**KIRKLEES METROPOLITAN COUNCIL
INVESTMENT & REGENERATION SERVICE**

DELEGATED DECISION TO DETERMINE PLANNING APPLICATIONS

Reference No:	2025/62/93487/W
Site Address:	2, Belton Grove, Birchenclyffe, Huddersfield, HD3 3RF
Description:	Erection of two storey and single storey side extensions with rear dormer and associated alterations
Recommending Officer:	Joshua Merriman

Officer Report – 2025/93487

CLIENT	Maria Hafeez		
ADDRESS	2 Belton Grove Huddersfield, HD3 3RF		
PROJECT	Side Extension and Rear Dormer		
DRAWING	Proposed LG and GF Layout		
DRAWN	UH	DATE	Aug 25
		SCALE	1.50@A1
DWG No.	2542/02A		
STATUS	PLANNING

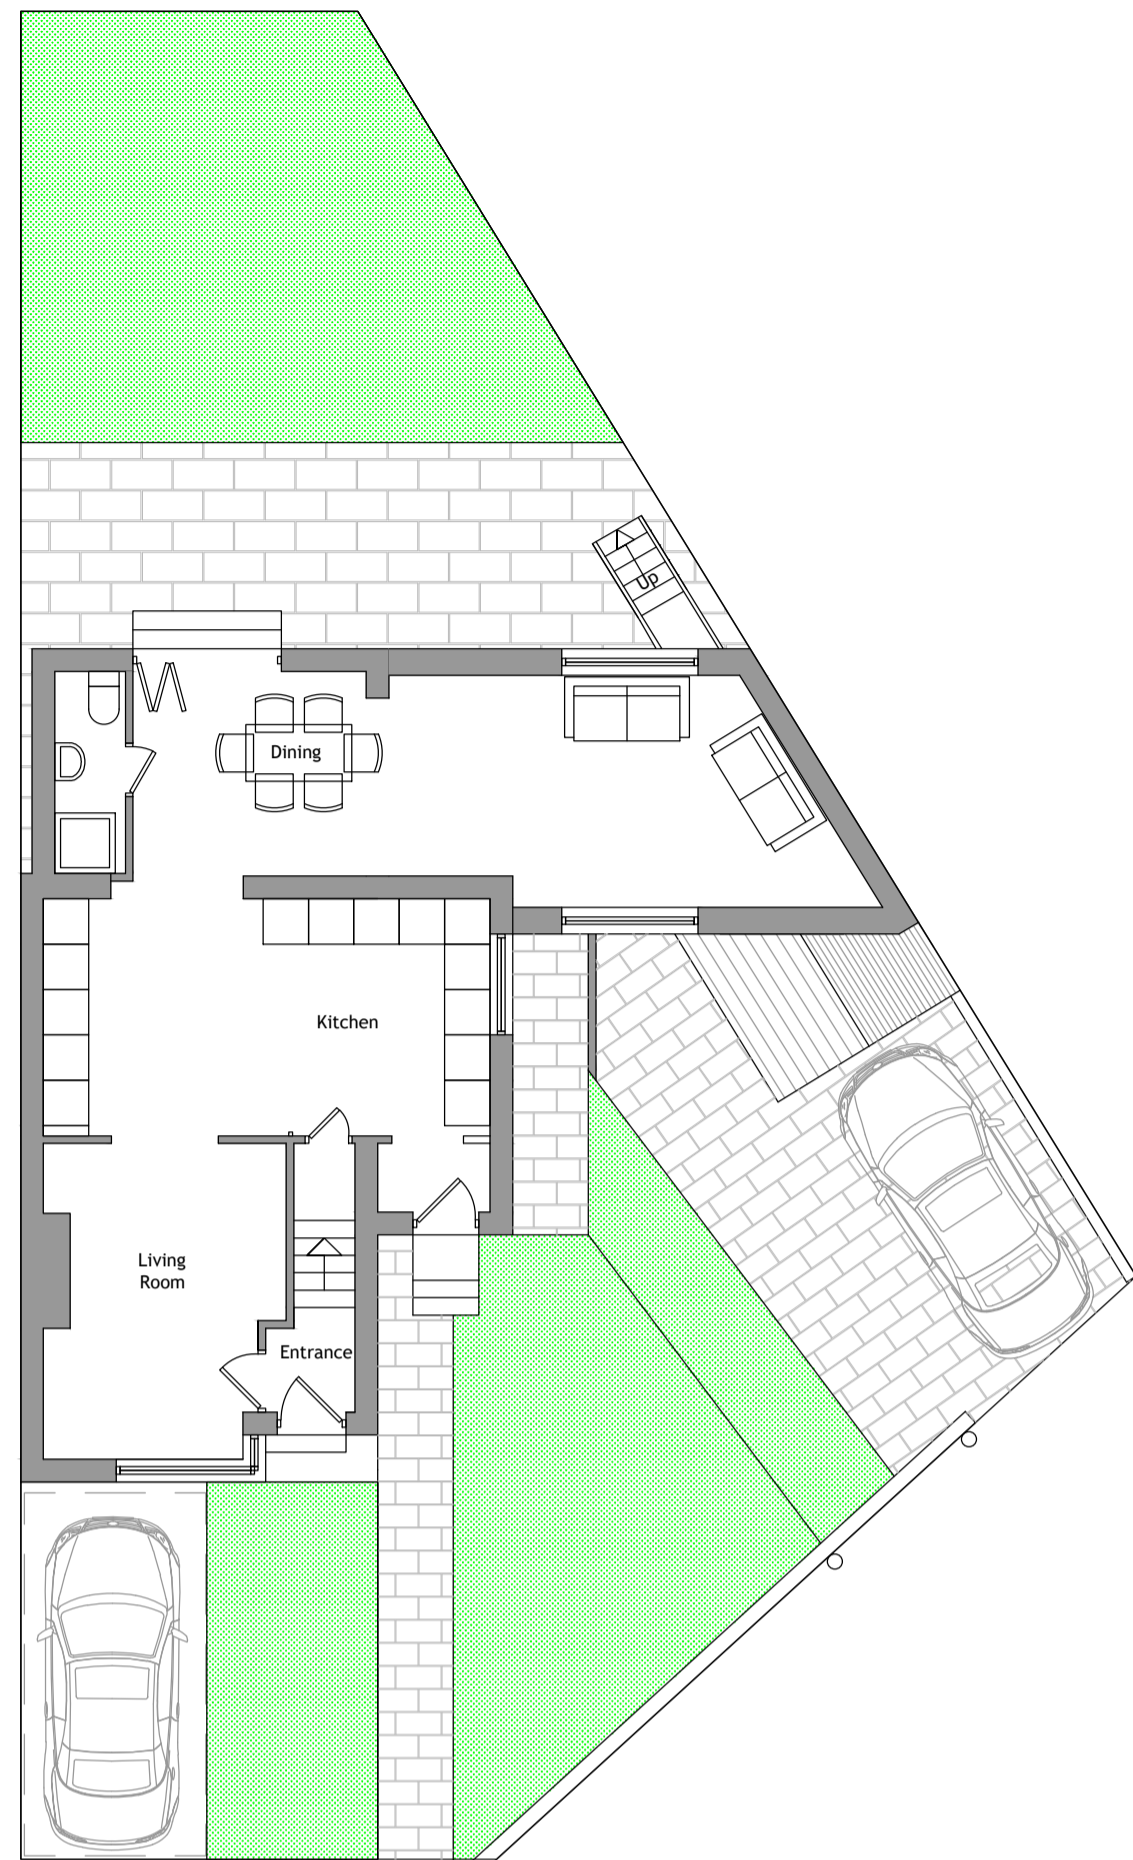
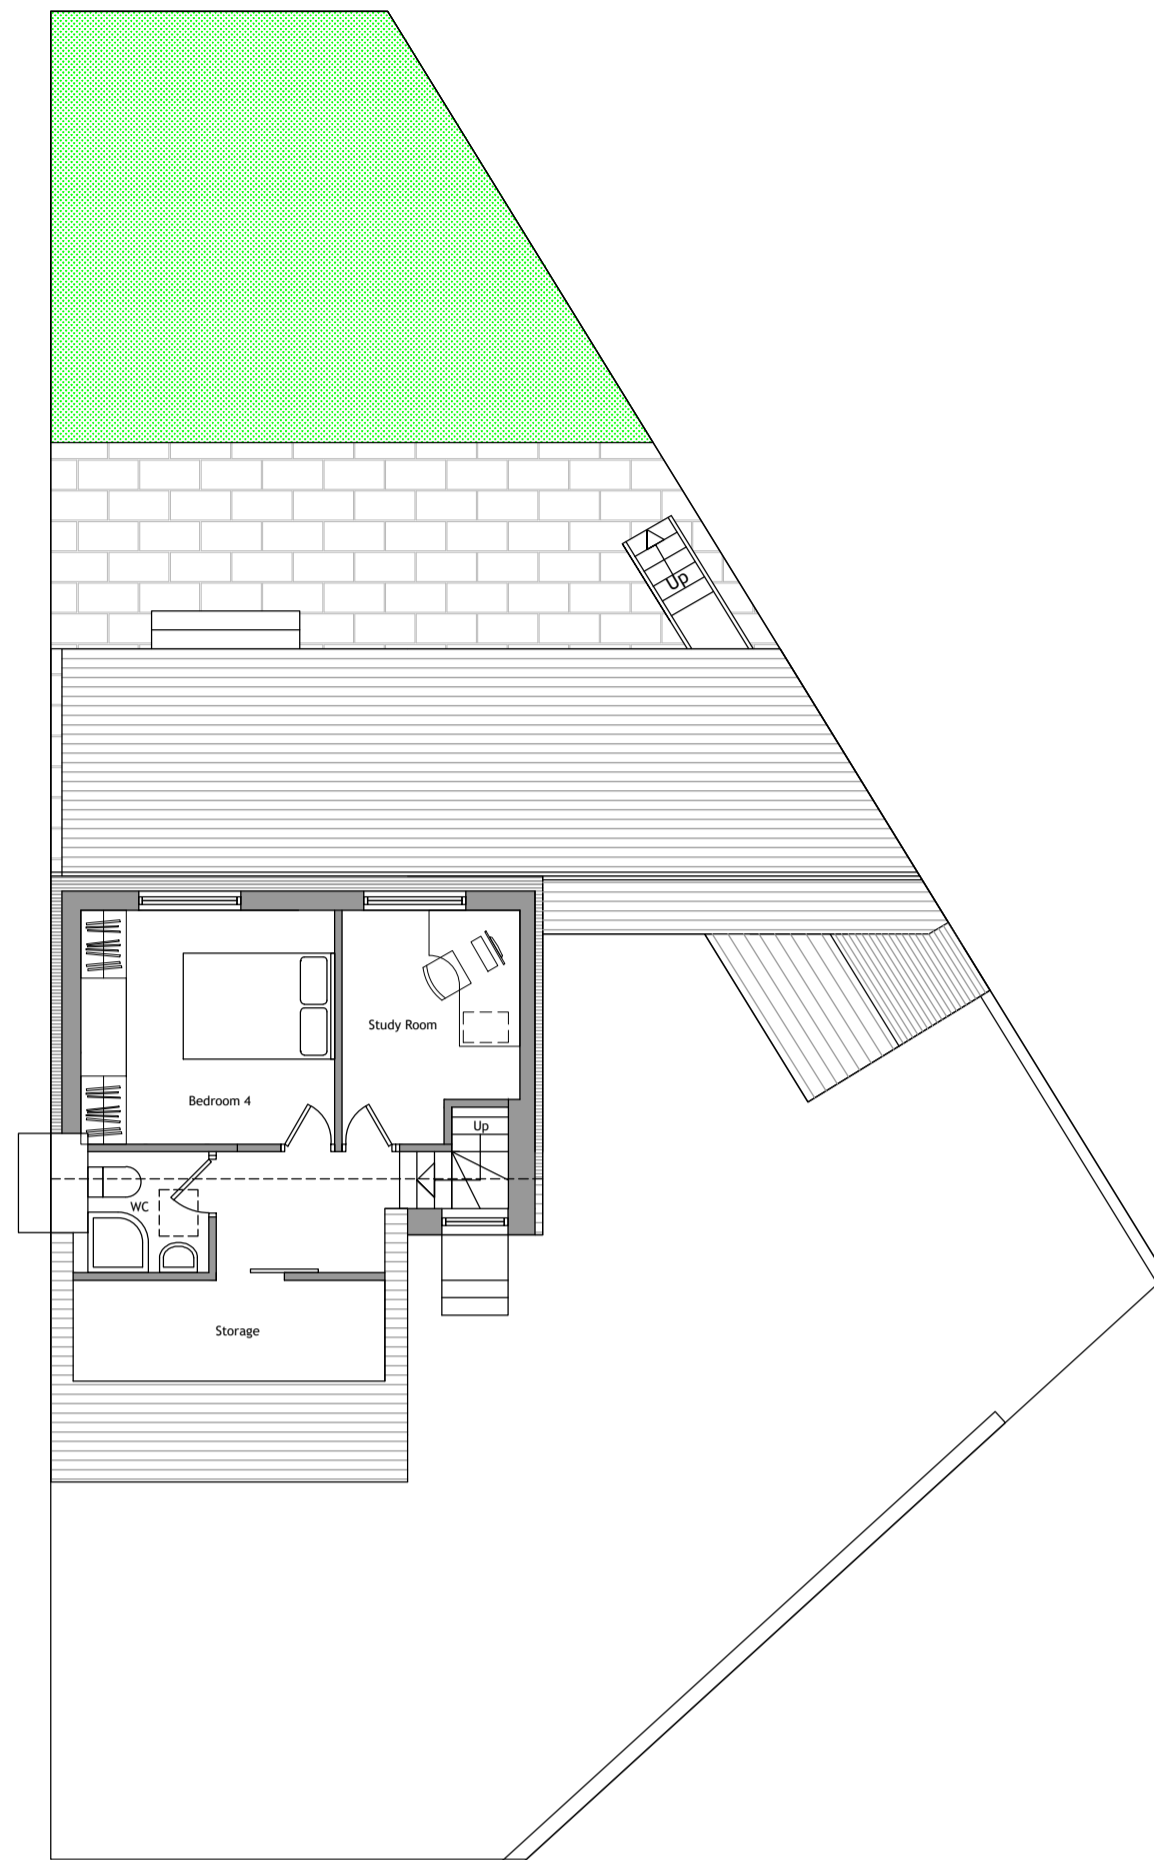
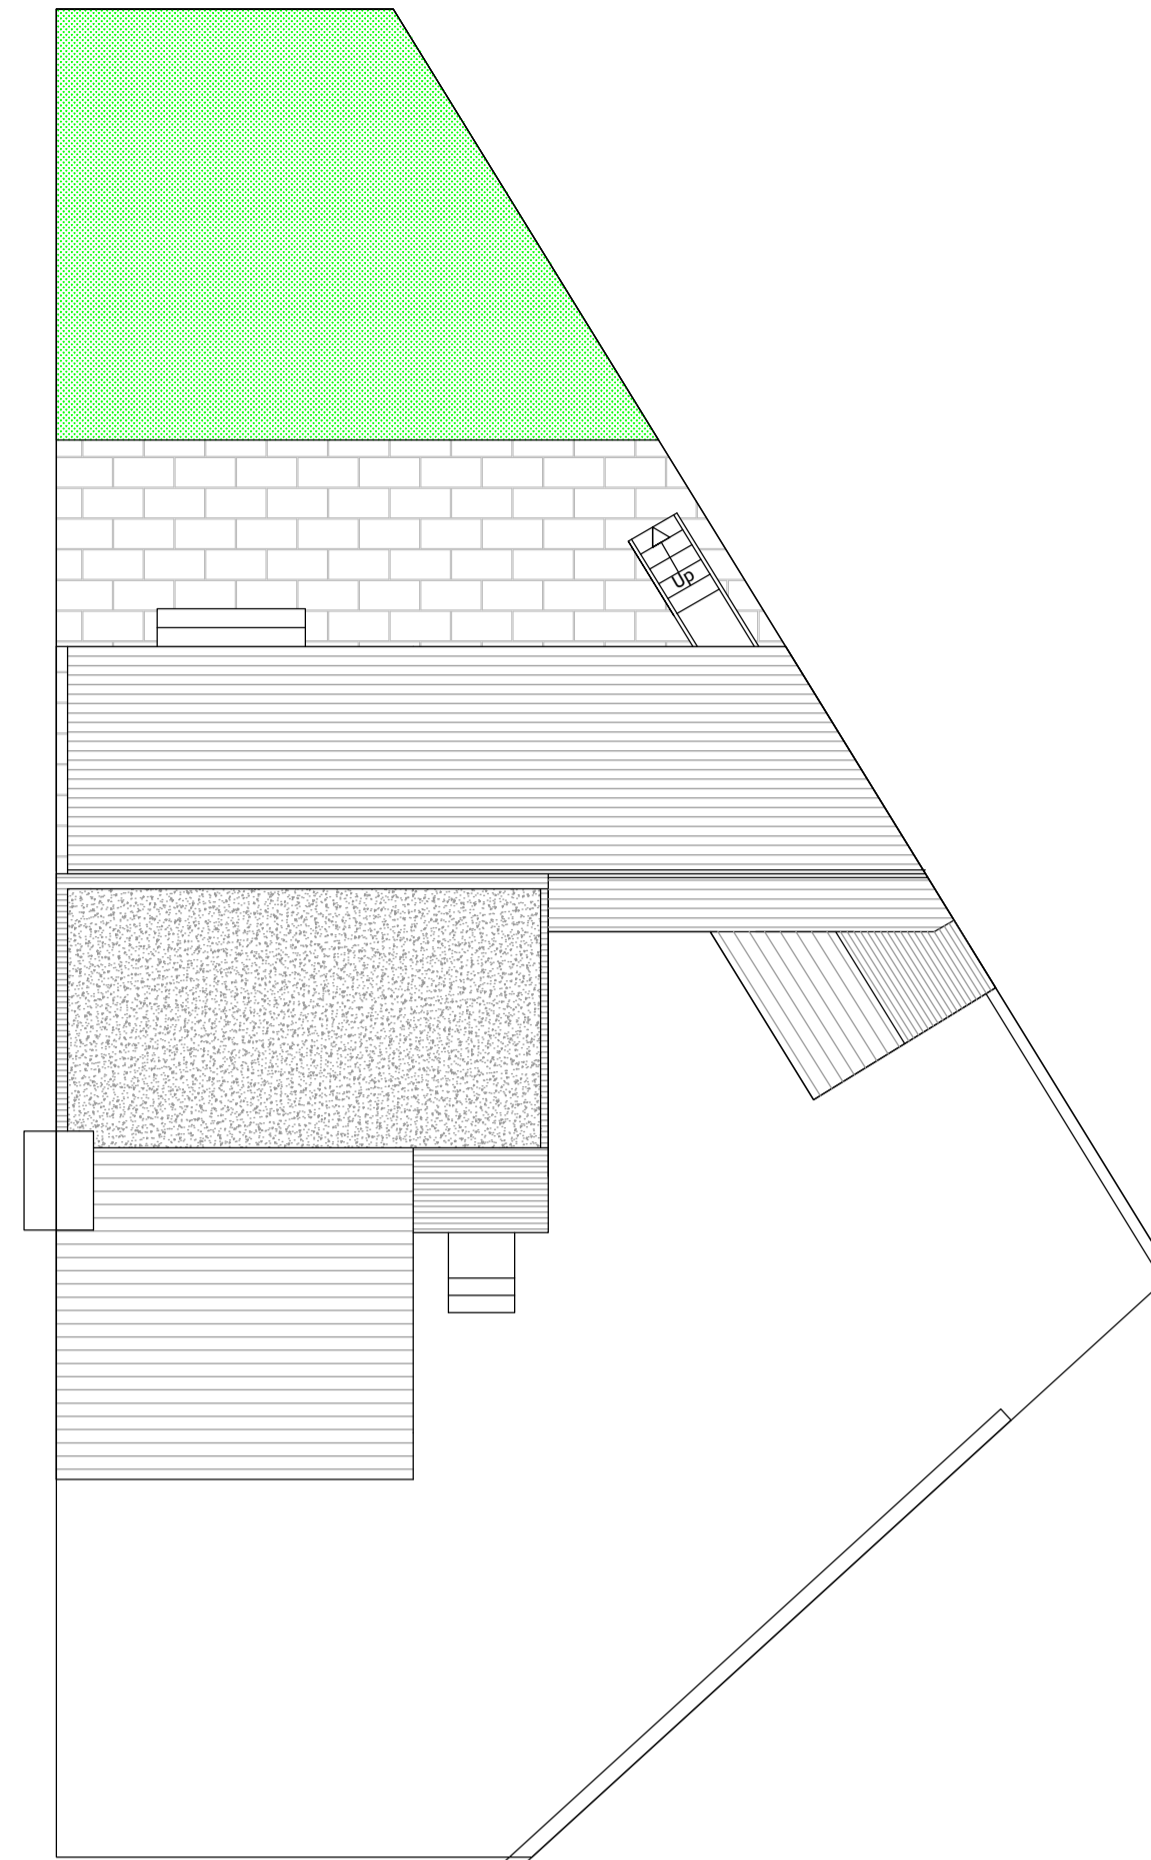
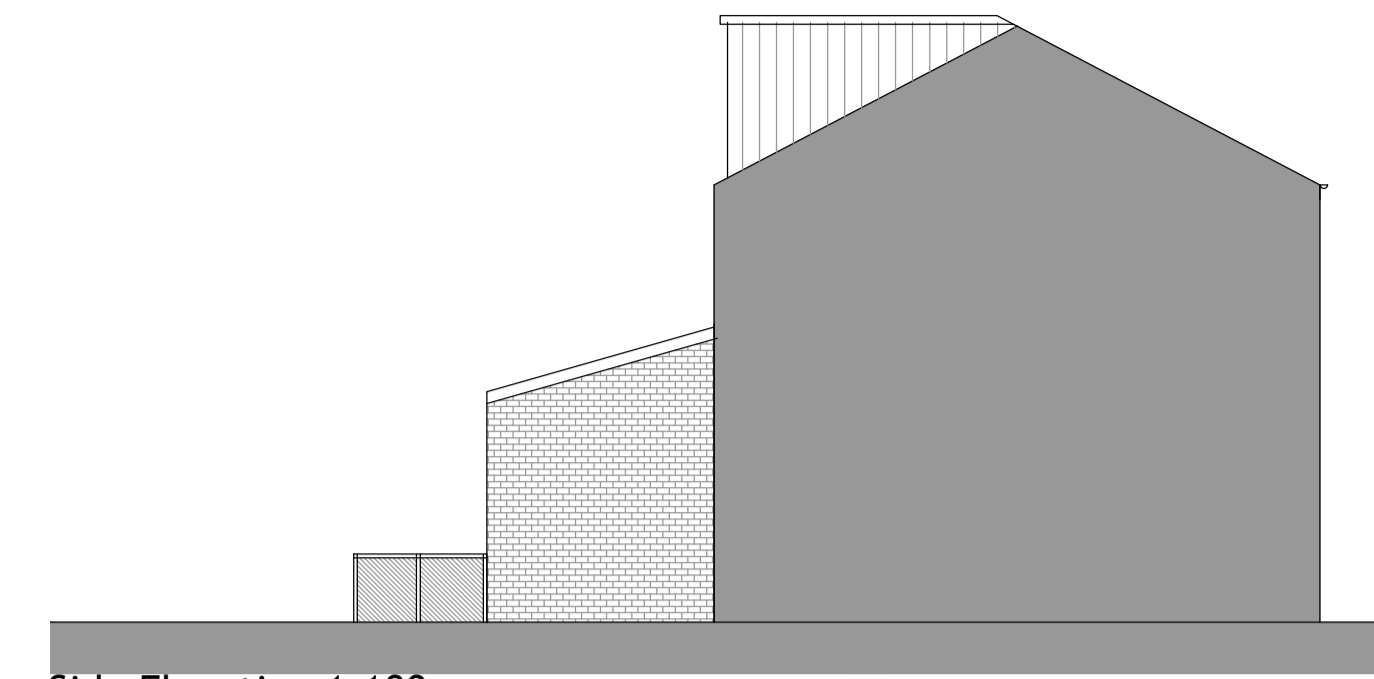
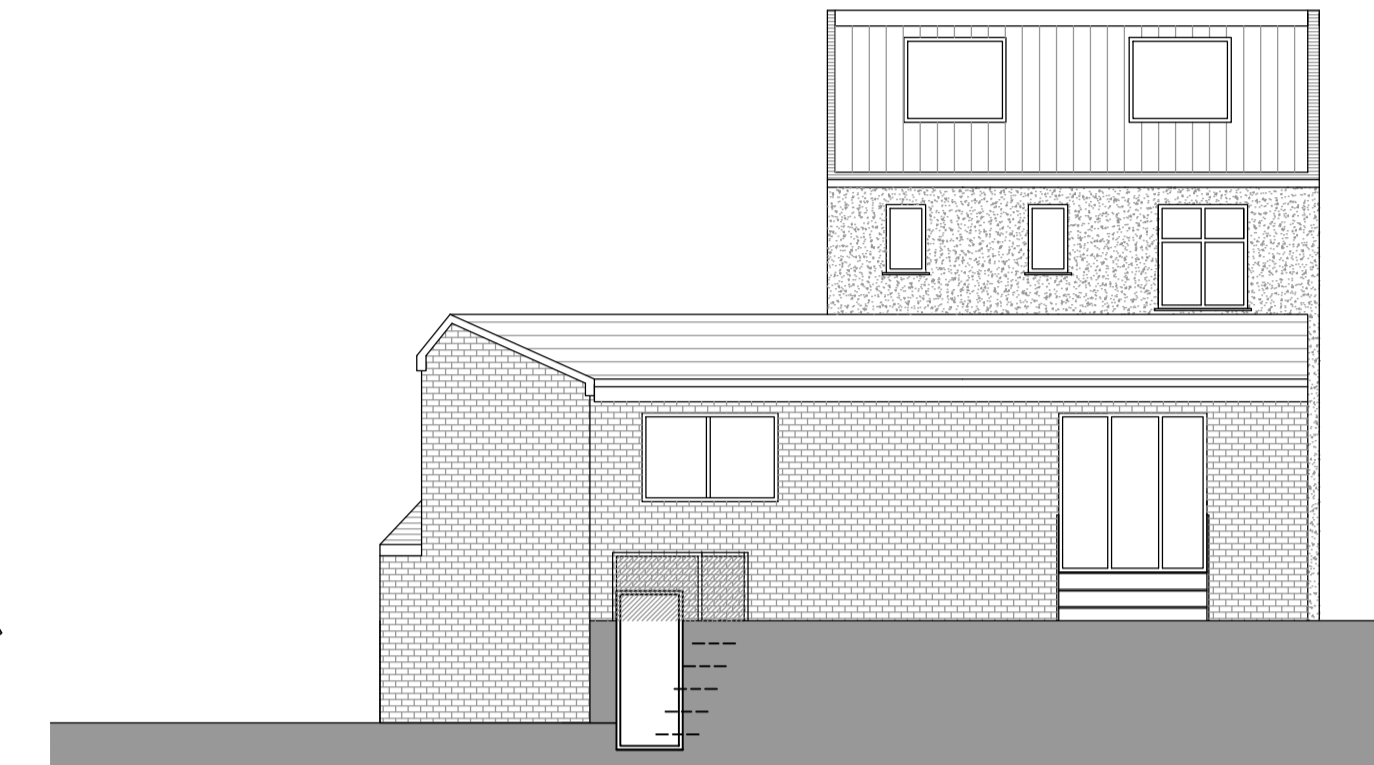
The amendments included reducing the width of the dormer to that of the original property, reducing overall height of dormer; squaring off the single storey side extension to increase visual appeal, an extended roof slope to the front elevation of the two storey side extension, removal of the window to the front elevation of the two storey side extension, windows changed to match those in the existing building.

- Concerns that the rear dormer extending directly to the shared boundary line would have an unreasonable impact upon the adjoined property and its development potential.
